Date: 10th December 2020

Our Ref: AW/319/20/DOC

**Town & Country Planning Act 1990 (as amended)**  
**Town and Country Planning (Development Management Procedure) (England) Order 2015**  
**Approval of details reserved by condition imposed under ref AW/197/20/PL relating to Condition Nos 1**  
**- window detail to front elevation, 2 - future access & maintenance of any watercourse and 7 - Service**  
**Management Plan.**  
**The Former Ship Inn Aldwick Street Aldwick PO21 3AP**

MULTIPLUS™

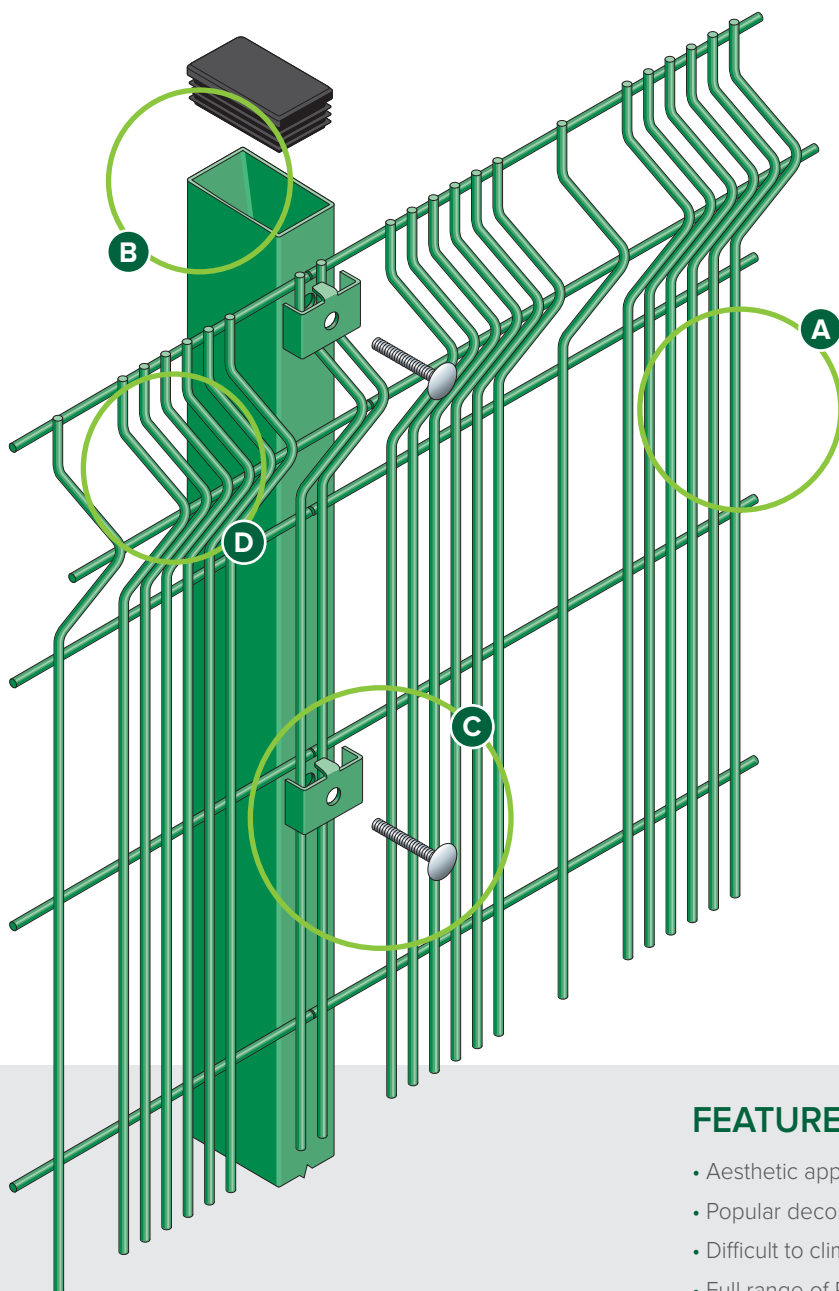
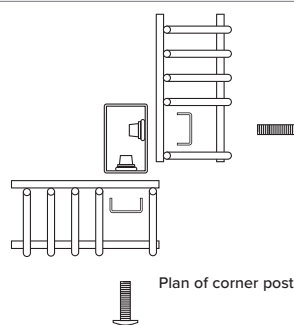
The details submitted in respect of this condition, namely drawing B210 "Fencing details to rear stream" and the accompanying Multiplus Profiled Panel System fence specification are considered to be generally acceptable with one caveat - that as per your emailed correspondence of 30/11/20 at 2.54pm (labelled on our website as "Applicant Response to Drainage Engineer Comments"), you will provide the post nearest to the gate leading edge/lock with a bolted cleat fixing (as opposed to being cast into concrete). This will allow for easy future removal to gain access to the watercourse.

The Councils Drainage Engineers agree with this approach and on this basis, the condition is fully discharged.
